Current Zoning: UR-C(CD) (urban residential – commercial, conditional)
Proposed Zoning: UR-C(CD) SPA (urban residential – commercial, conditional, site plan amendment)

Approximately 1.08 acres located on the west side of Providence Road, north of Ardsley Road, and south of Moravian Lane.

The petition proposes a site plan amendment to a previously approved petition, 2011-008, to allow for the site to be redeveloped with nonresidential uses.

RZ-1.0

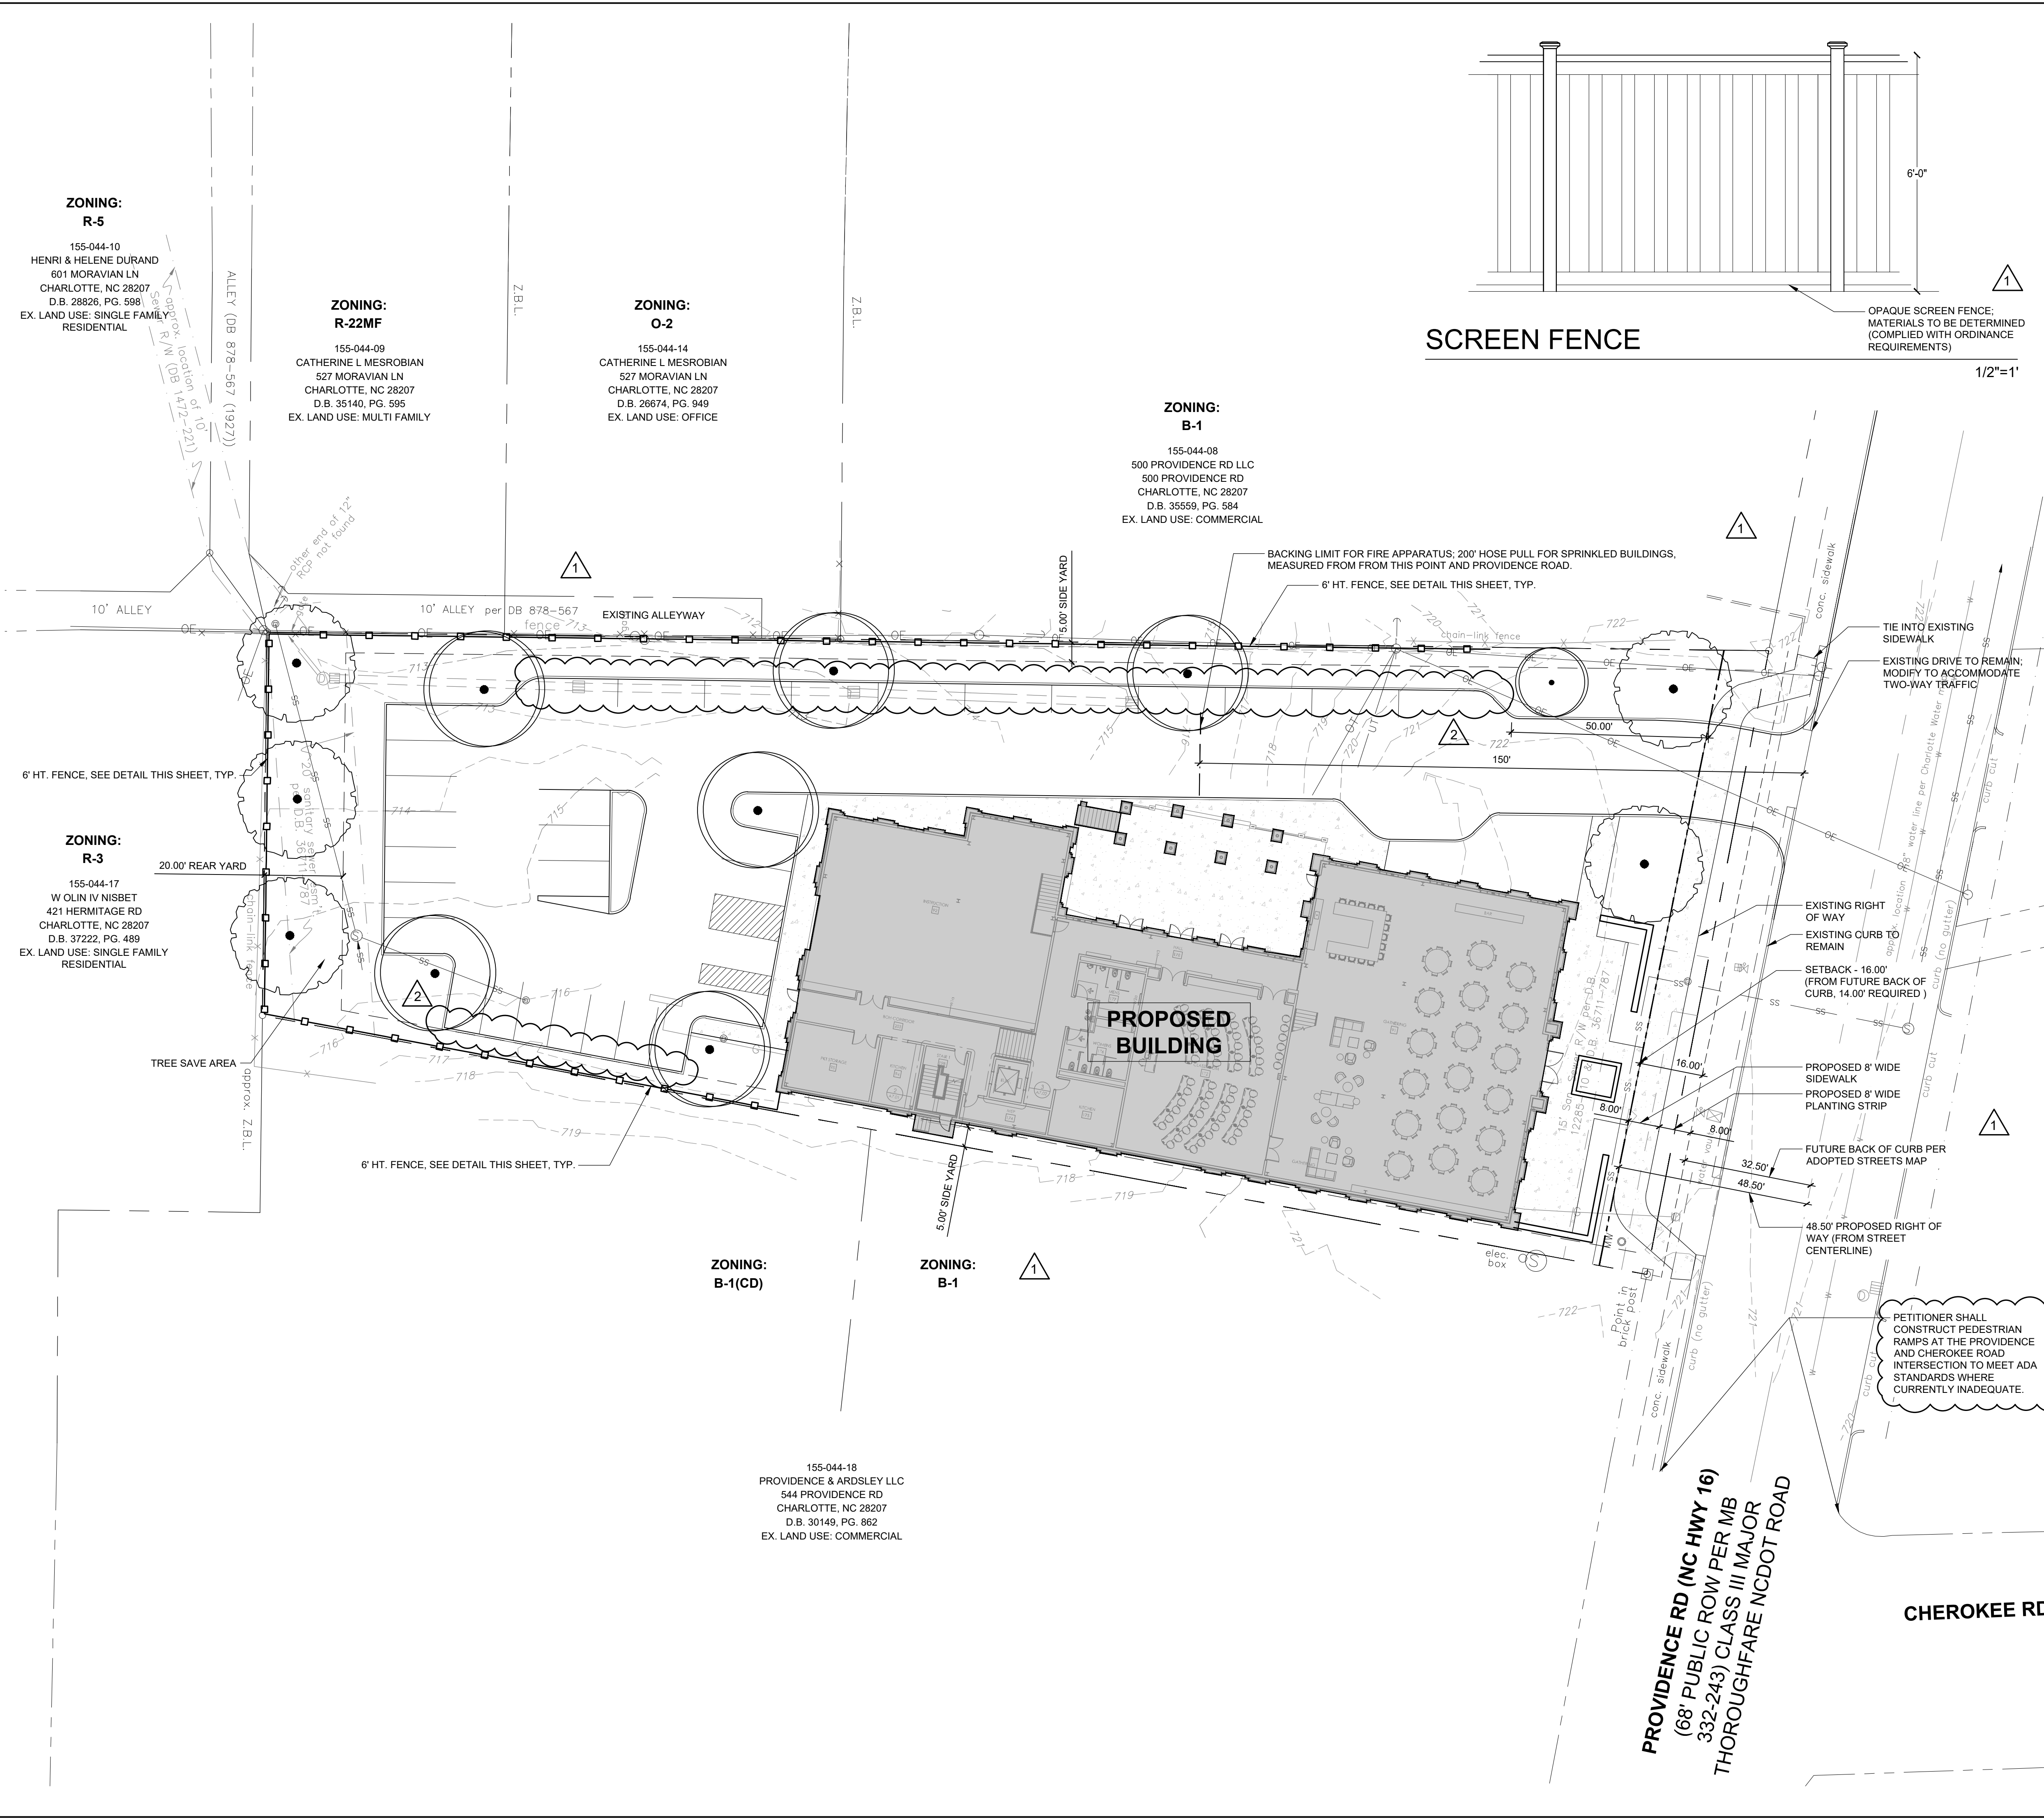
2. Revise the parking spaces on the northern and southern boundaries so that they do not extend into the side yards.

3. The site plan shows a fence along a portion of the southern boundary, but the conditional notes only mention fencing on northern and southern boundaries. Clarify fencing commitments and update the notes as needed.
